Date: 25 January 2022  
Our ref: 380668  
Your ref: TR010044

**NSIP Reference Name / Code: TR010044 A428 Black Cat to Caxton Gibbet Road  
Improvement scheme – NE Response to Information Submitted for Deadline 8  
User Code: 20028237**

Our comments below focus on the Applicant's *9.54 Barbastelle Bat Surveys and Mitigation Technical Note (Rev 4)* and *9.99 Habitats Regulations Assessment Report to Inform Appropriate Assessment*.

Drawing Number
HE551495 -ACM -ELS -
GEN_SW_Z_ZZ_DR-LV-0006

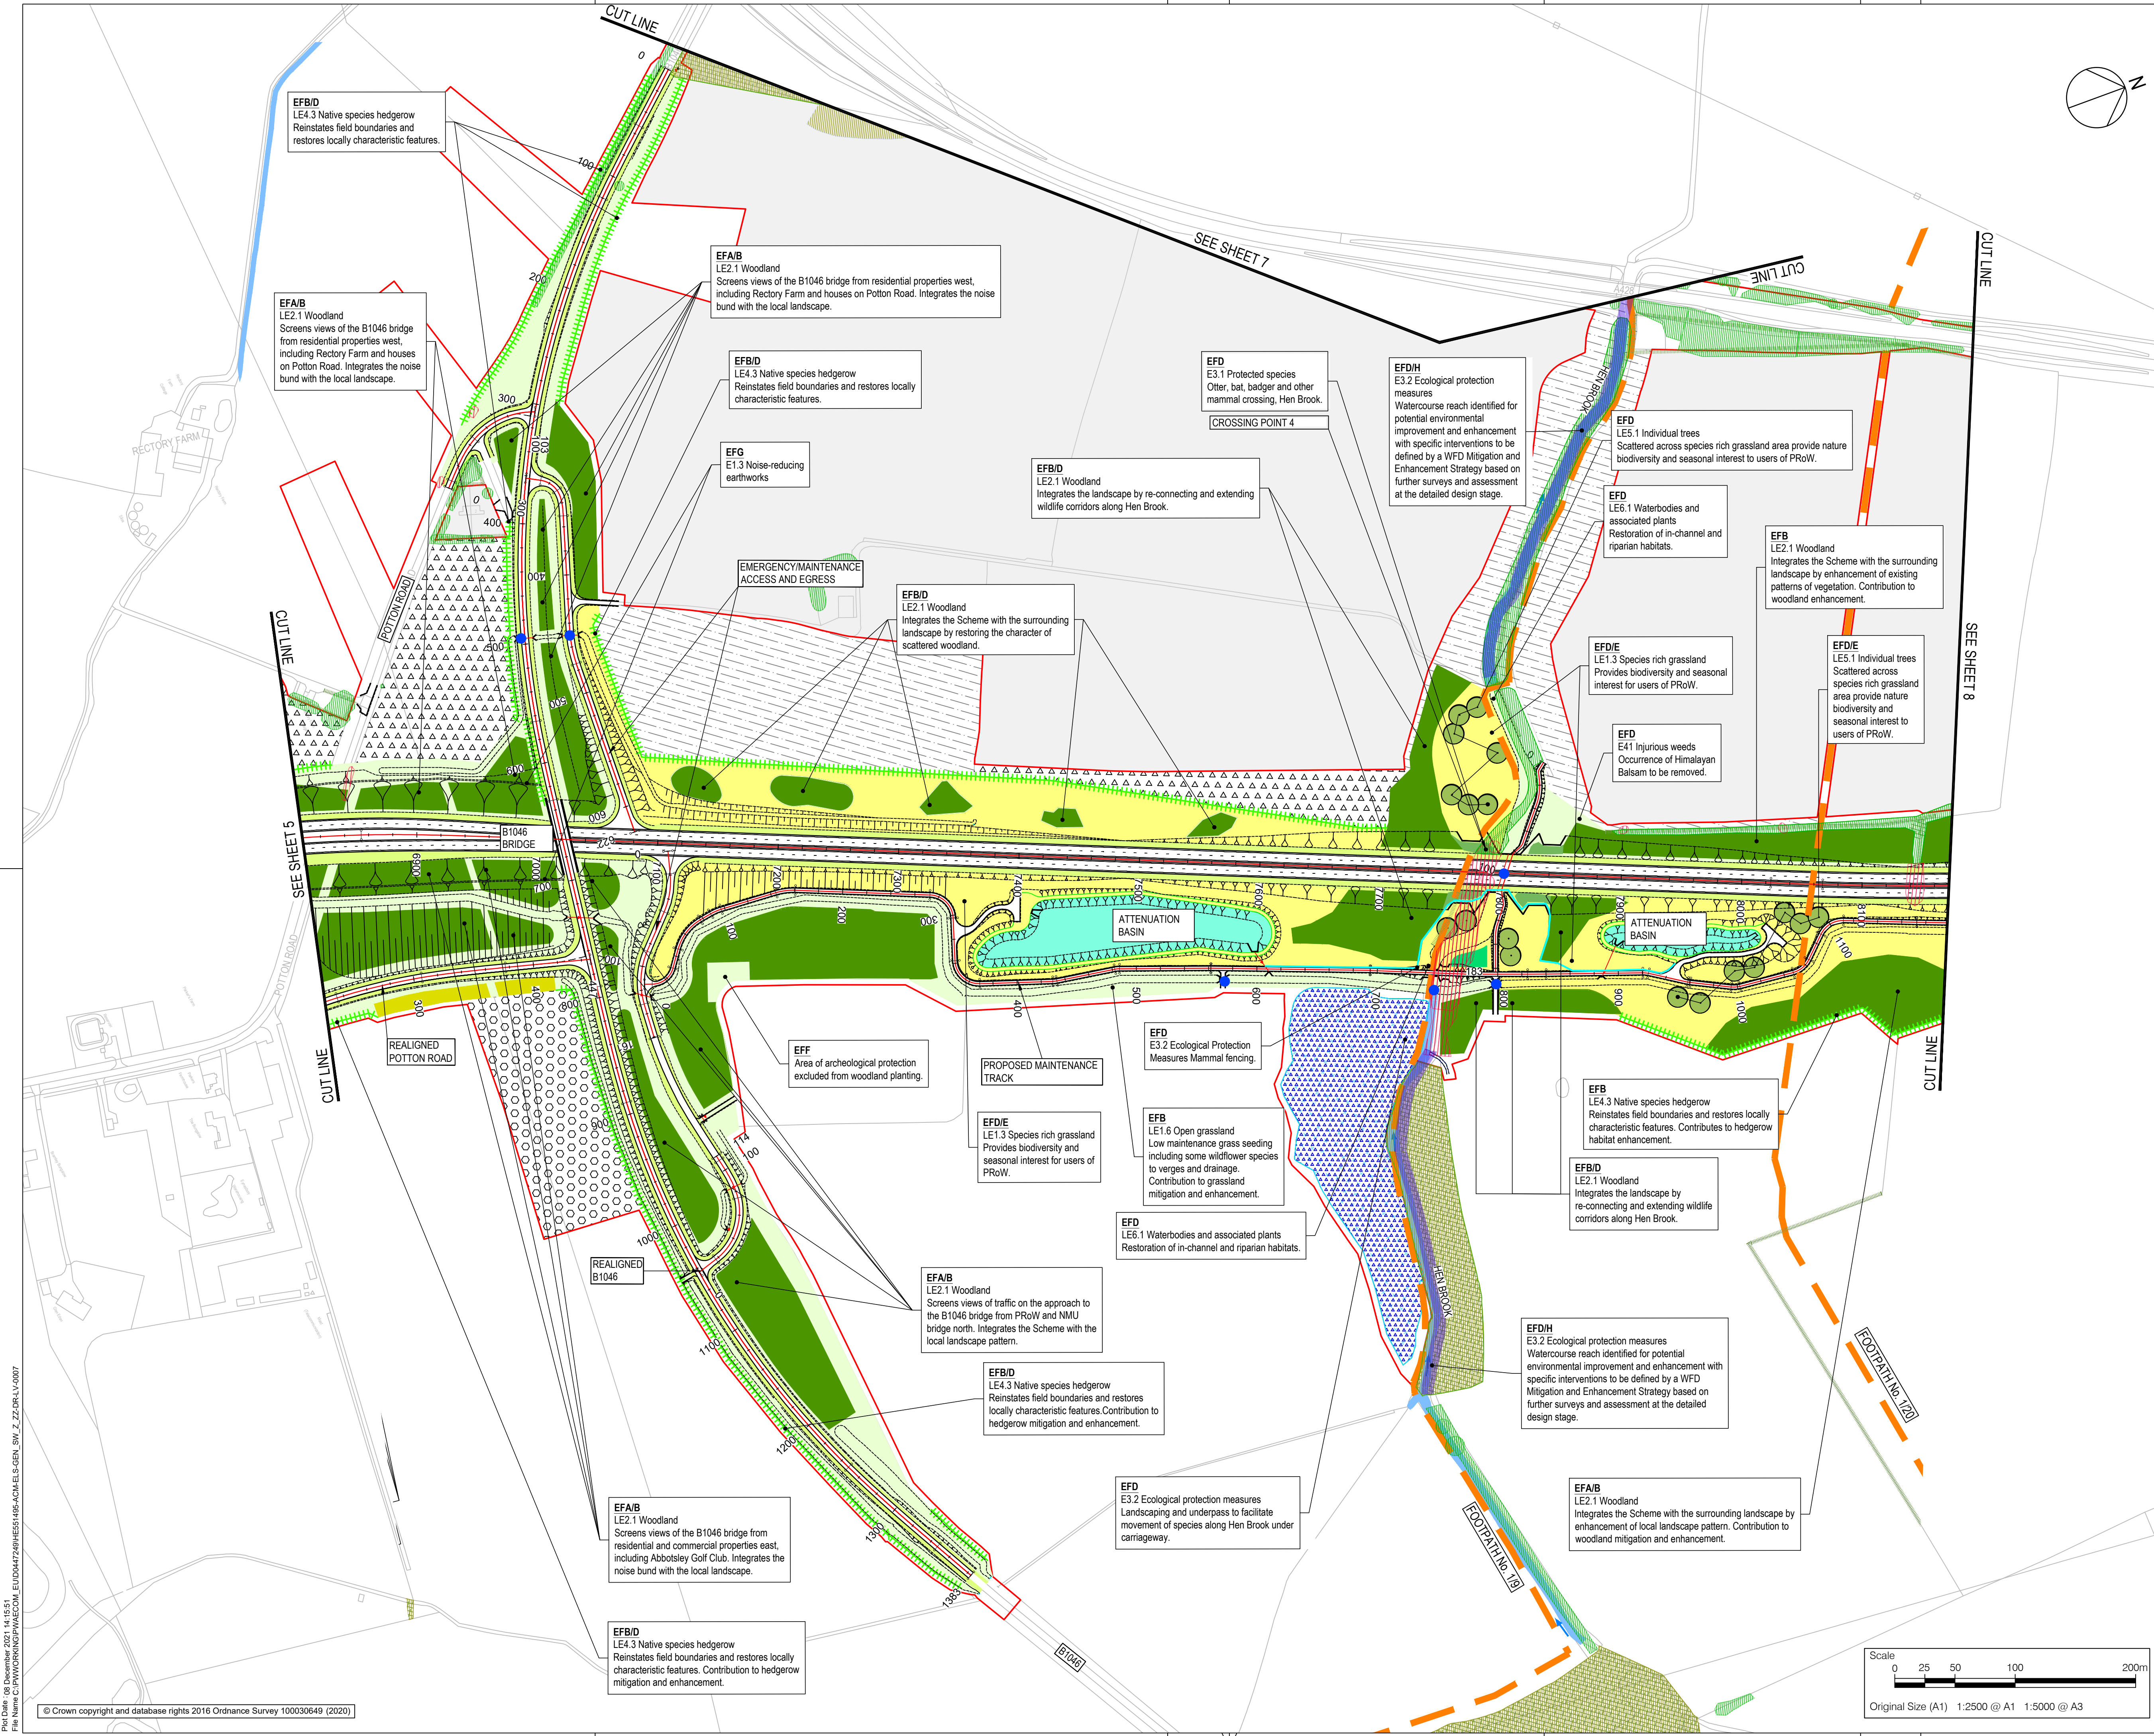
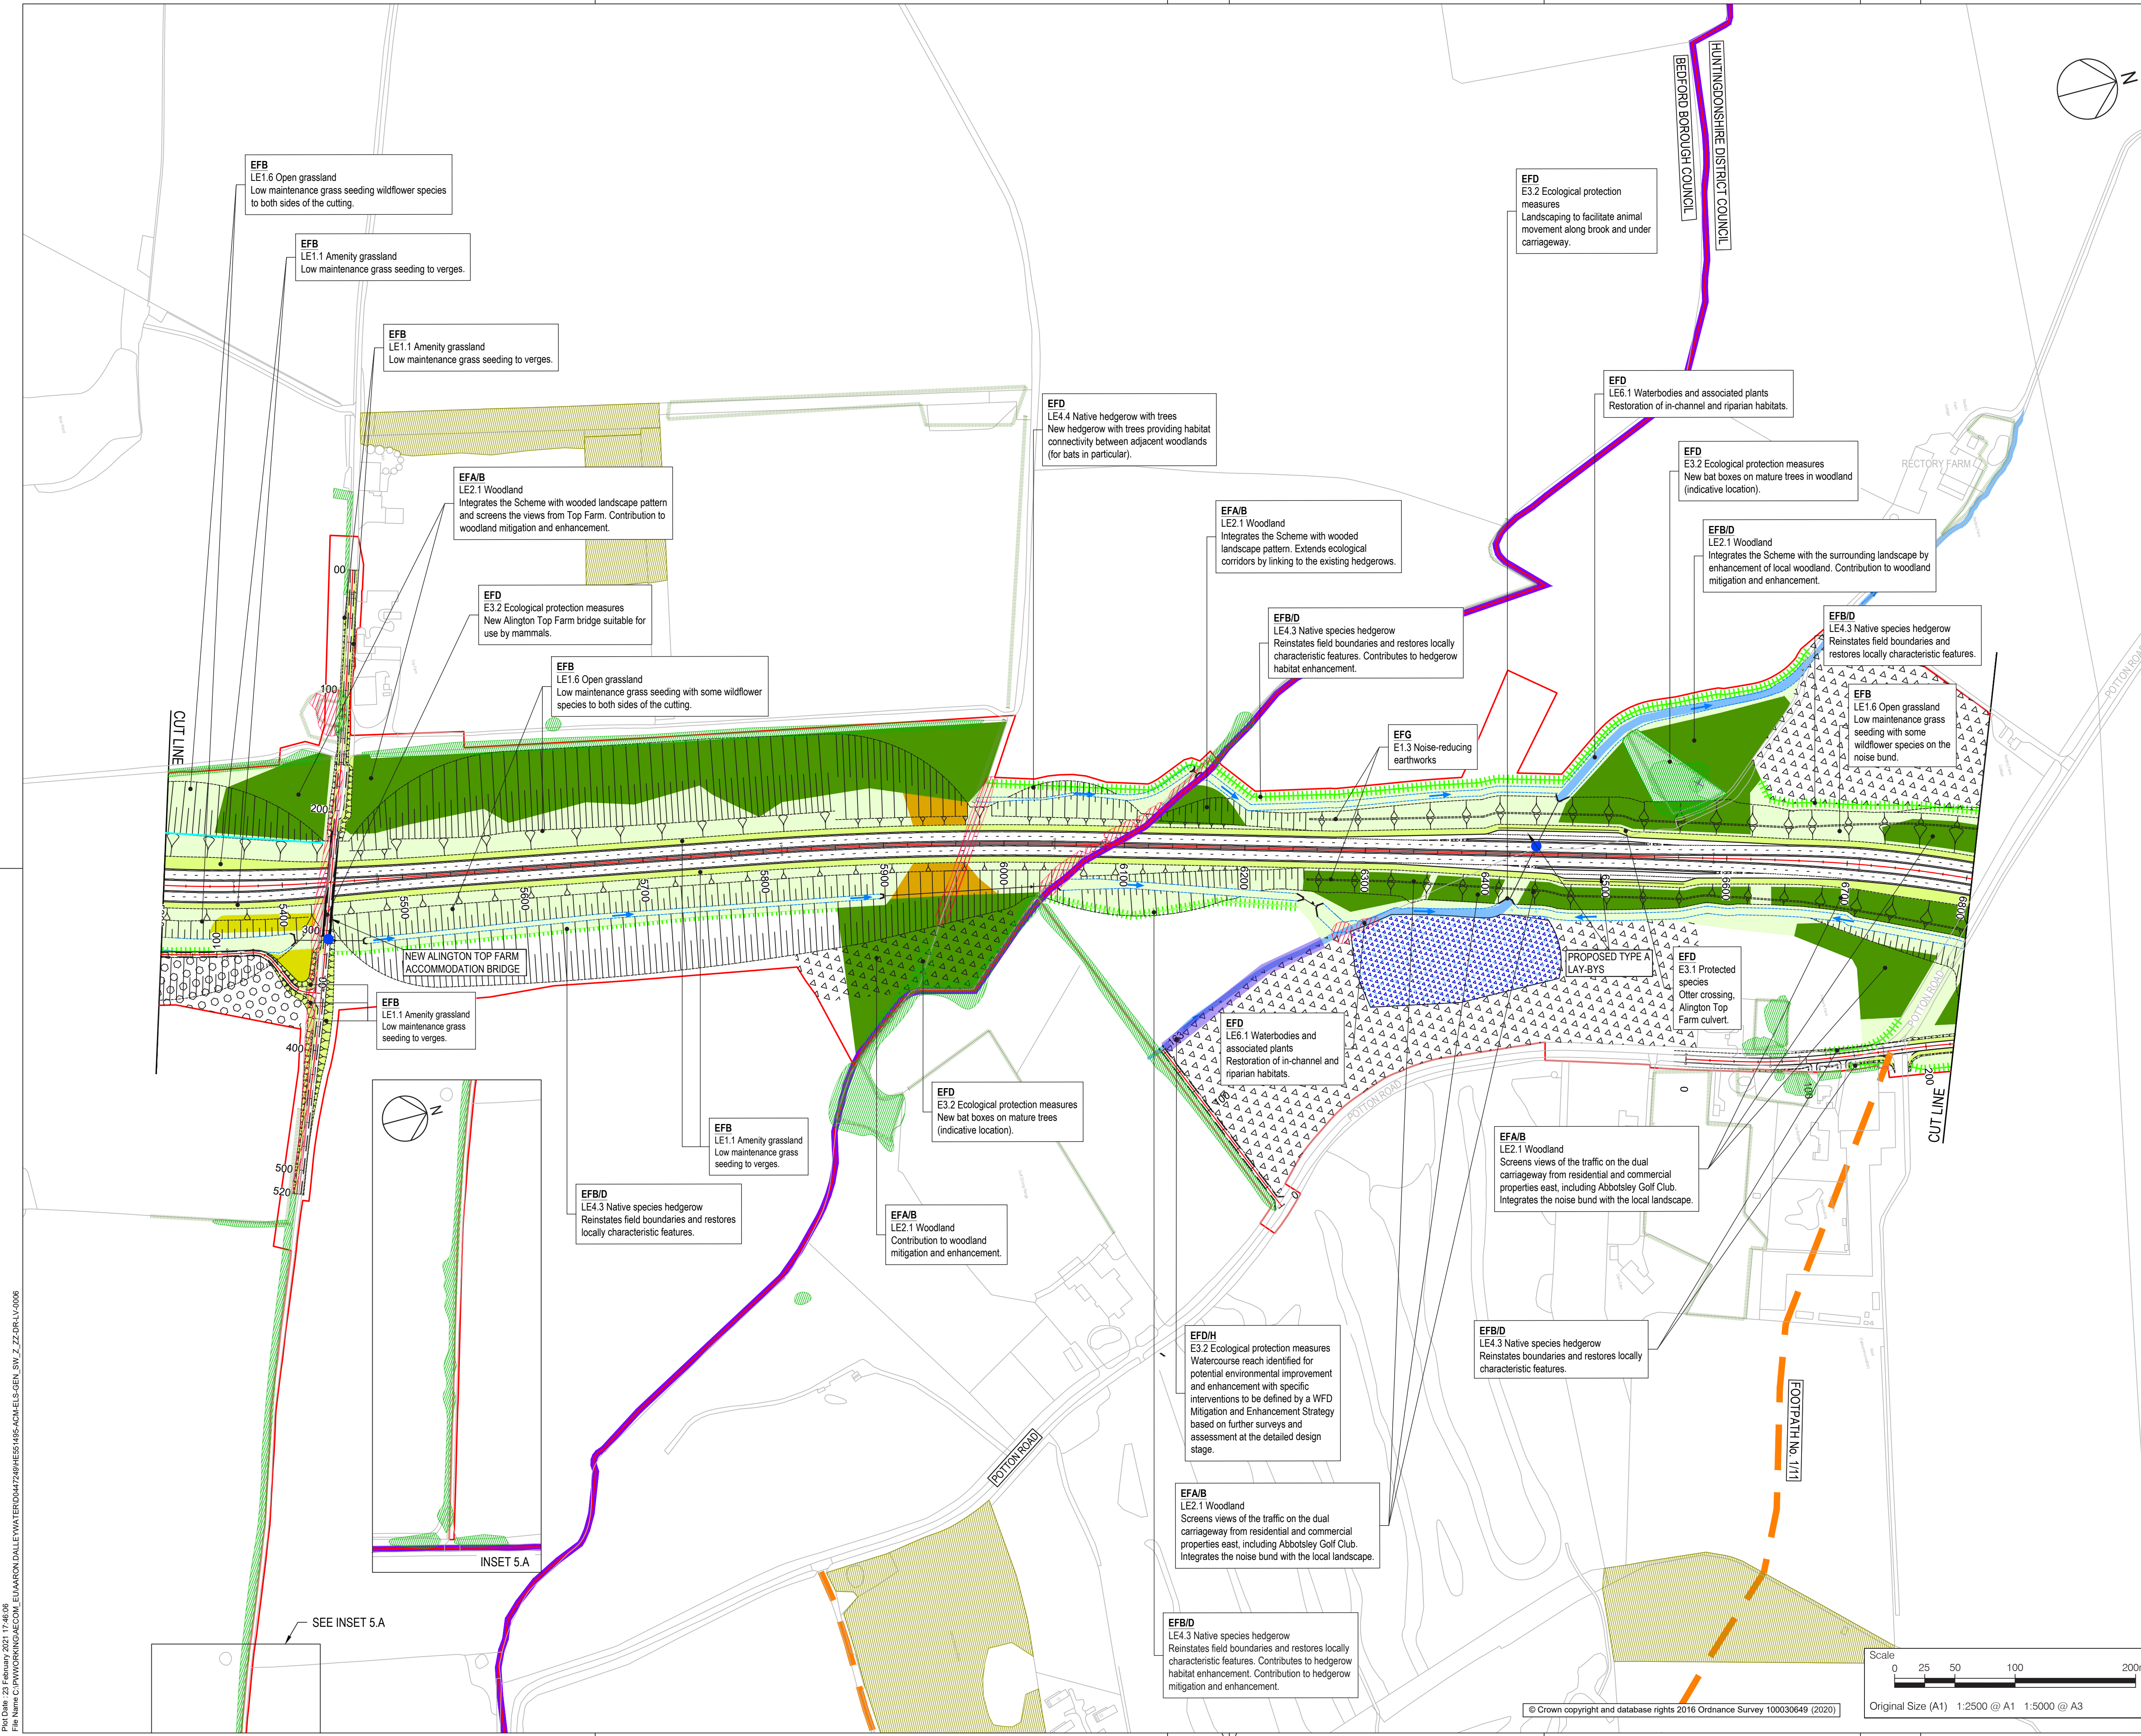
The Environmental Master Plan [REP4-047] identifies habitat creation around crossing structures

that have not been designed specifically for bats but that are perceived to be of potential future value to bats. We note that there are several locations where the Masterplan refers to construction lay down compounds/ storage areas which could provide habitat enhancement opportunities for bats, and wider biodiversity net gain, through appropriate restoration and habitat creation post-construction. Natural England would welcome further information from the Applicant regarding the potential to progress environmental enhancements in these areas.
